March 11, 2019
File: PE4194-LET.04

Subject: **Additional Groundwater Sampling
City File No. D07-12-17-0173 and D02-02-17-0126
Re: Phase II ESA
443 and 447 Kent Street and 423-425 McLeod Street
Ottawa, Ontario**

Paterson Group (Paterson) have prepared this letter in response to comments issued by the City of Ottawa (City) with regard to the proposed development of 443 and 447 Kent Street and 423-425 McLeod Street via e-mail on February 21, 2019. Specifically, the comments addressed herein pertain to the outstanding issues related to the Phase II ESA.

DRAWING PE4194-3 – TEST HOLE LOCATION PLAN

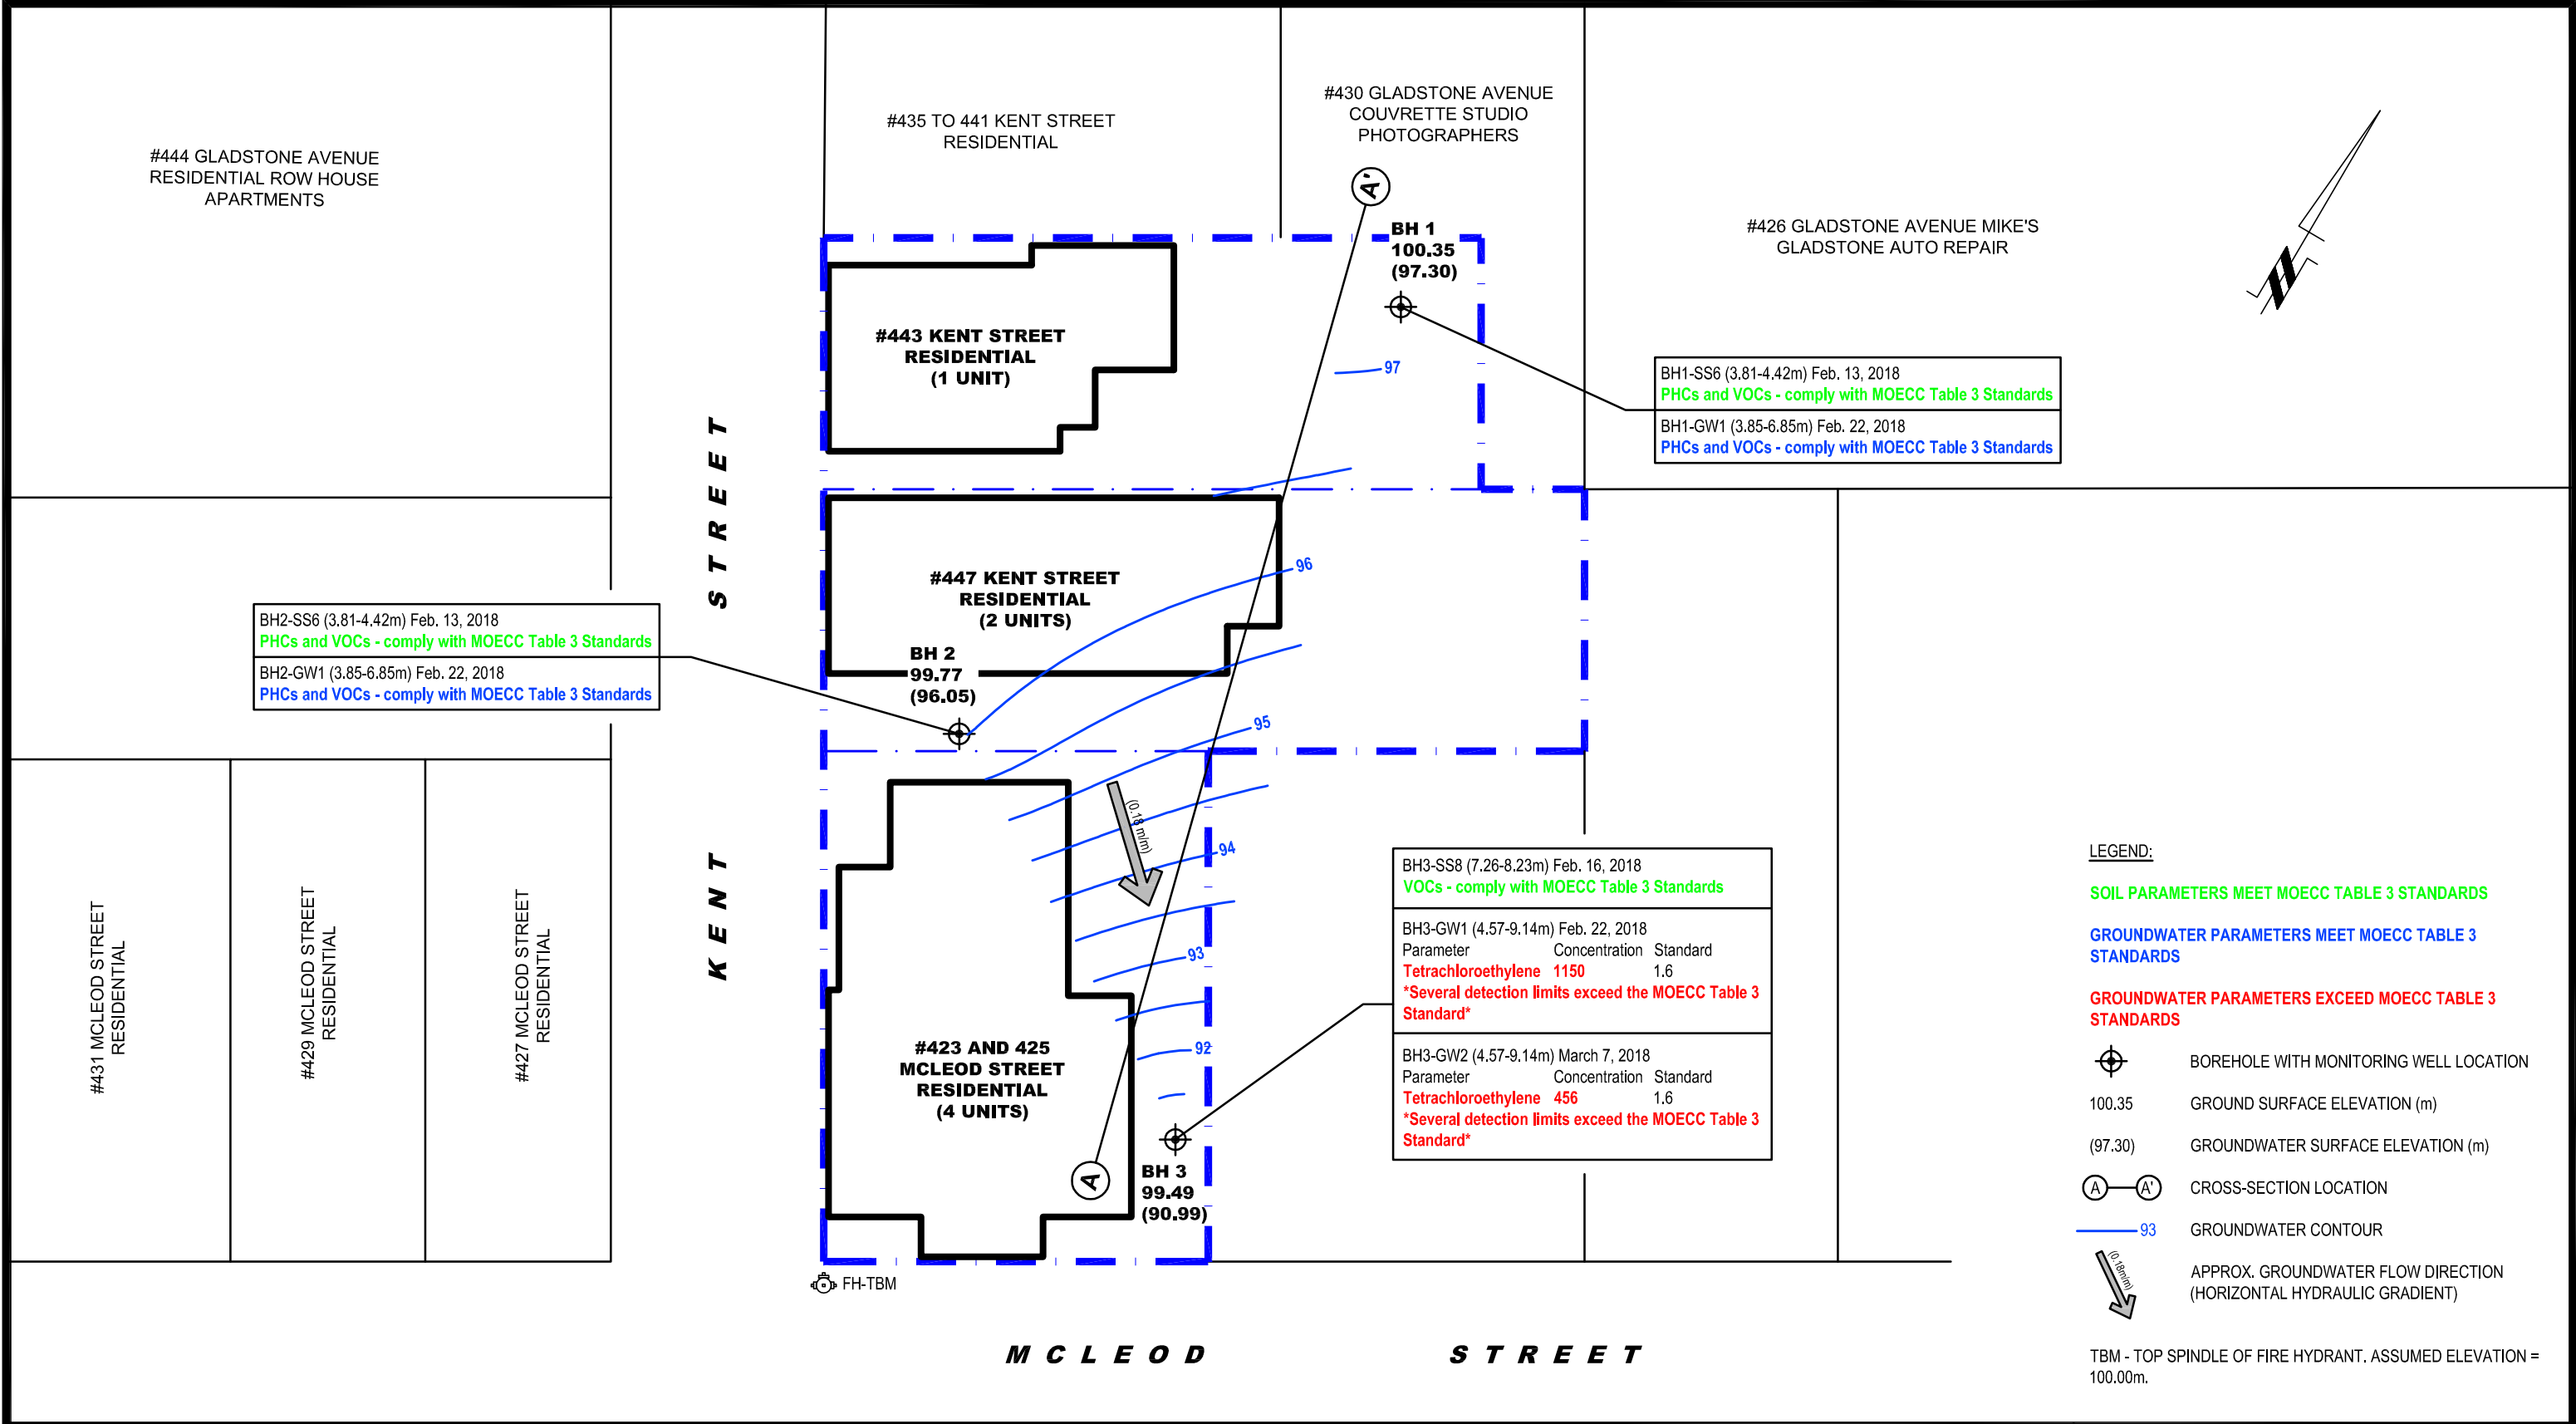
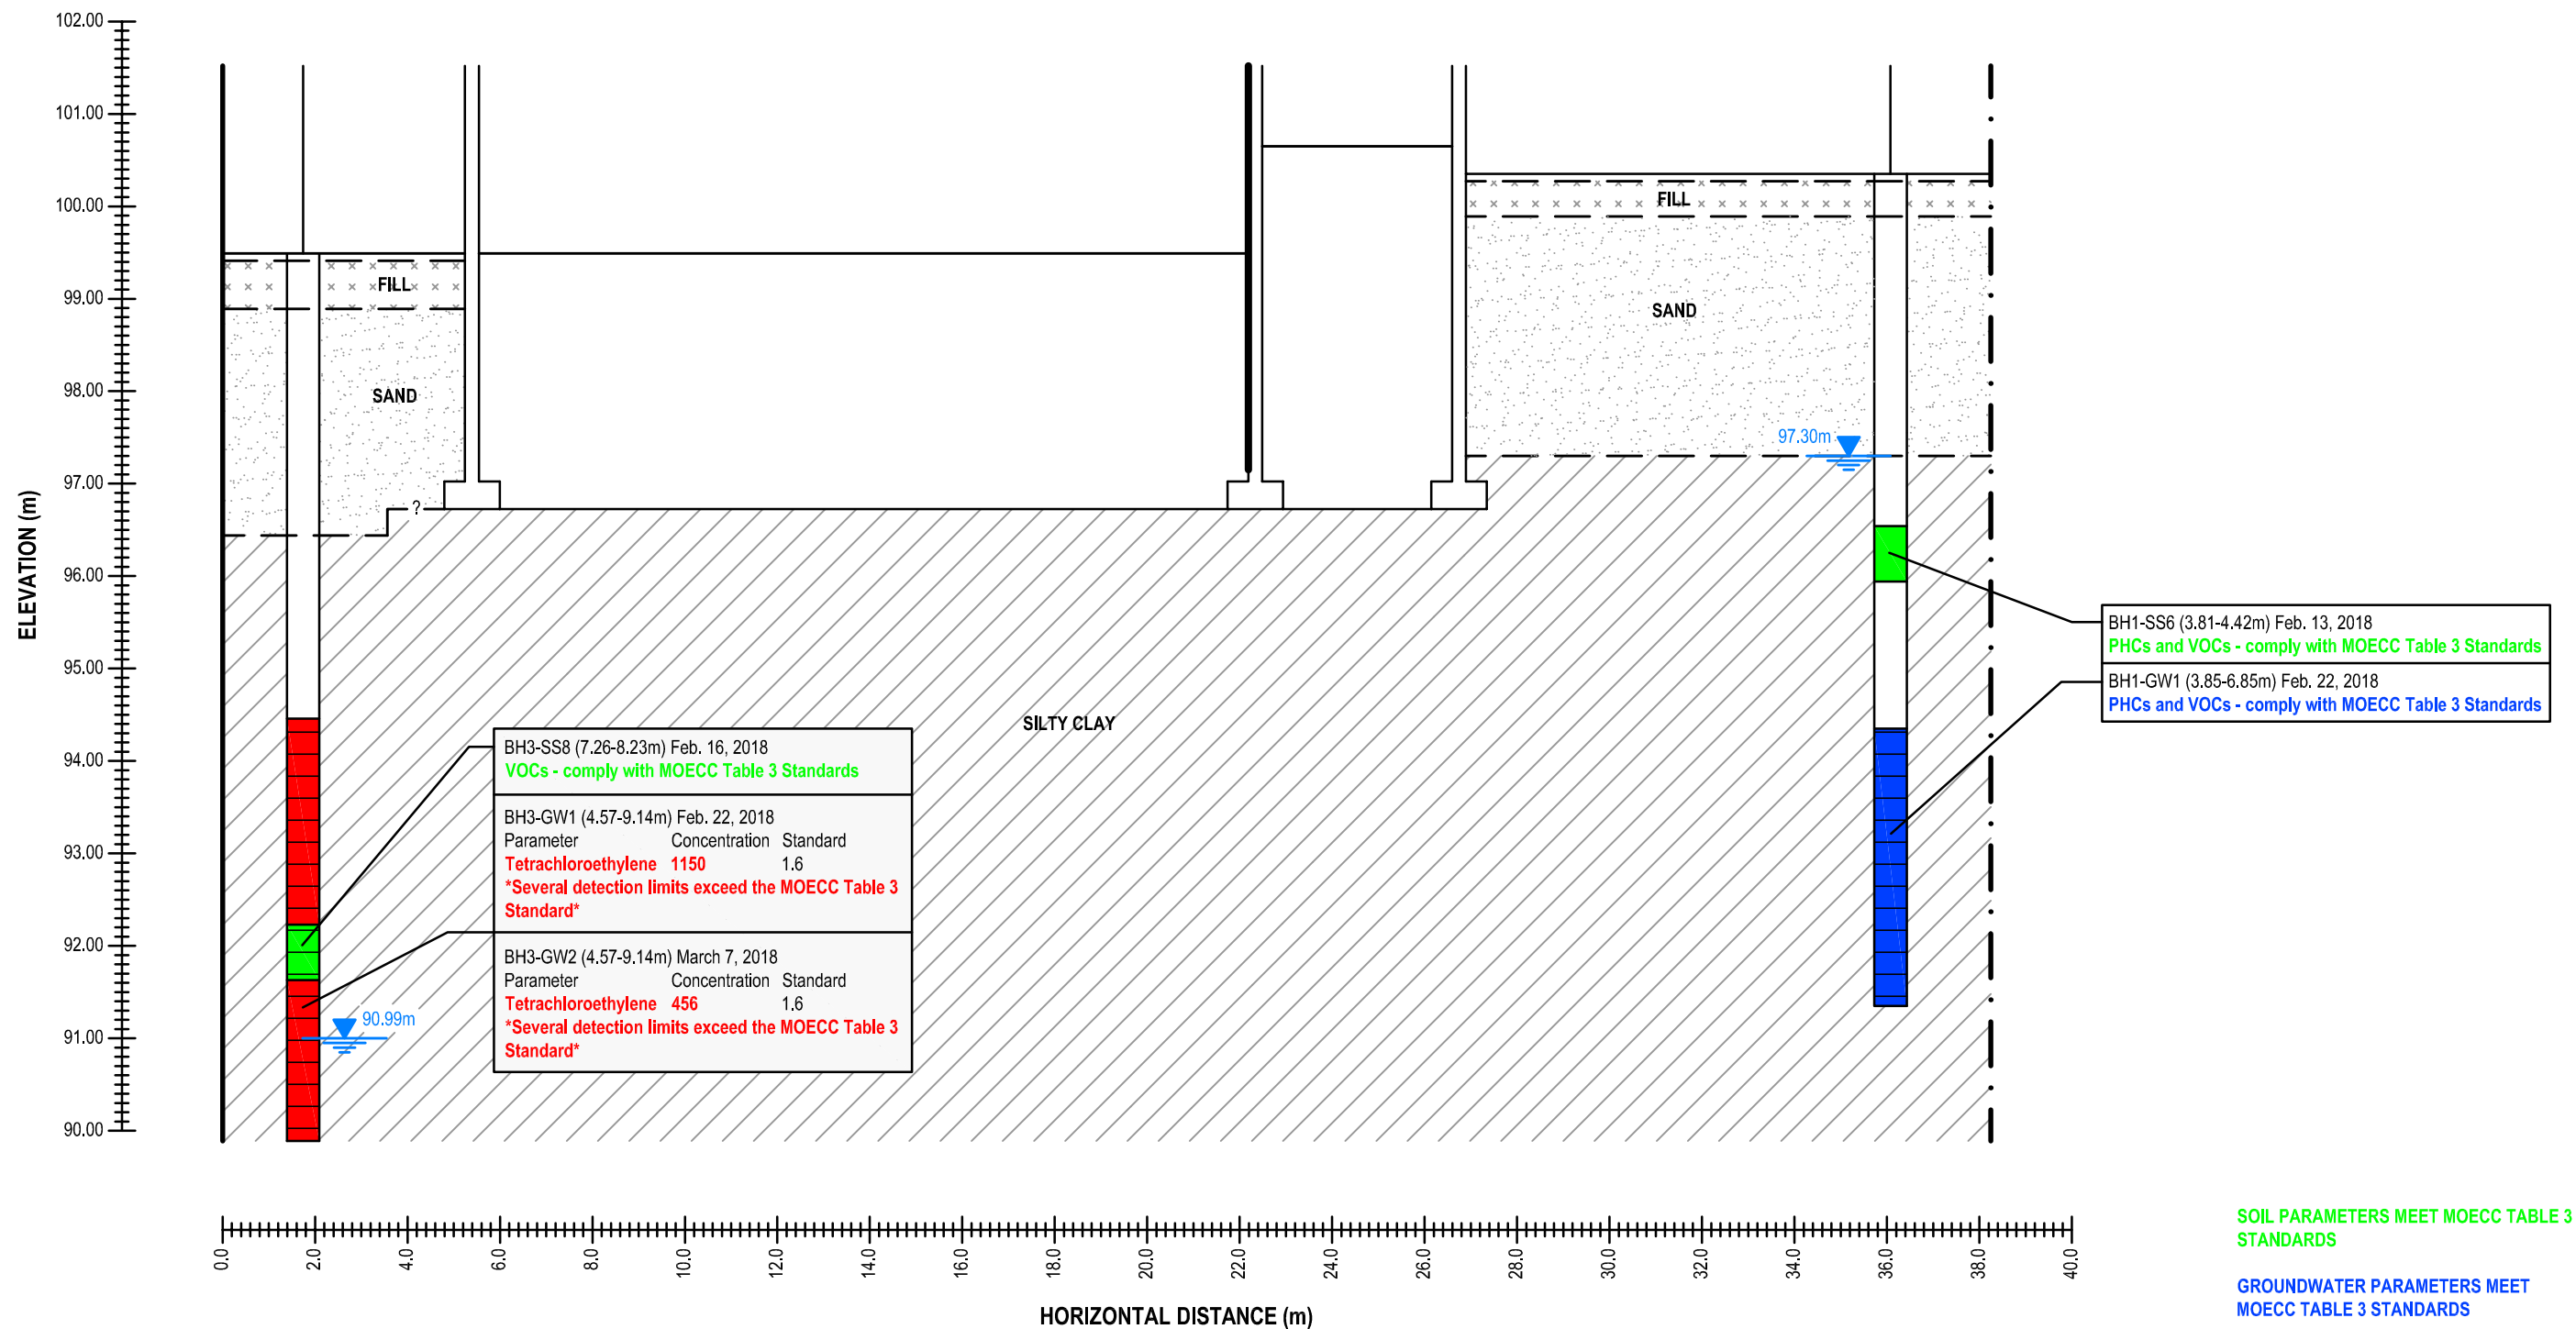
- ❑ Groundwater levels at all five monitoring wells were measured on February 21, 2019. Based on the water levels on the subject site it remains the position of Paterson that the groundwater levels in BH4 and BH5 have not stabilized.

Based on all the groundwater levels collected at the subject site since the original Phase II ESA, the deep monitoring wells (BH3, BH4 and BH5) do not stabilize for several months. The groundwater levels from BH4 and BH5 can reasonably be excluded from groundwater flow direction mapping. Based on the groundwater levels from the three stabilized monitoring wells (BH1, BH2 and BH3) the groundwater flow direction is to the west.

It is recommended that the well in BH3 be maintained throughout the redevelopment of the subject site for potential future groundwater monitoring purposes.
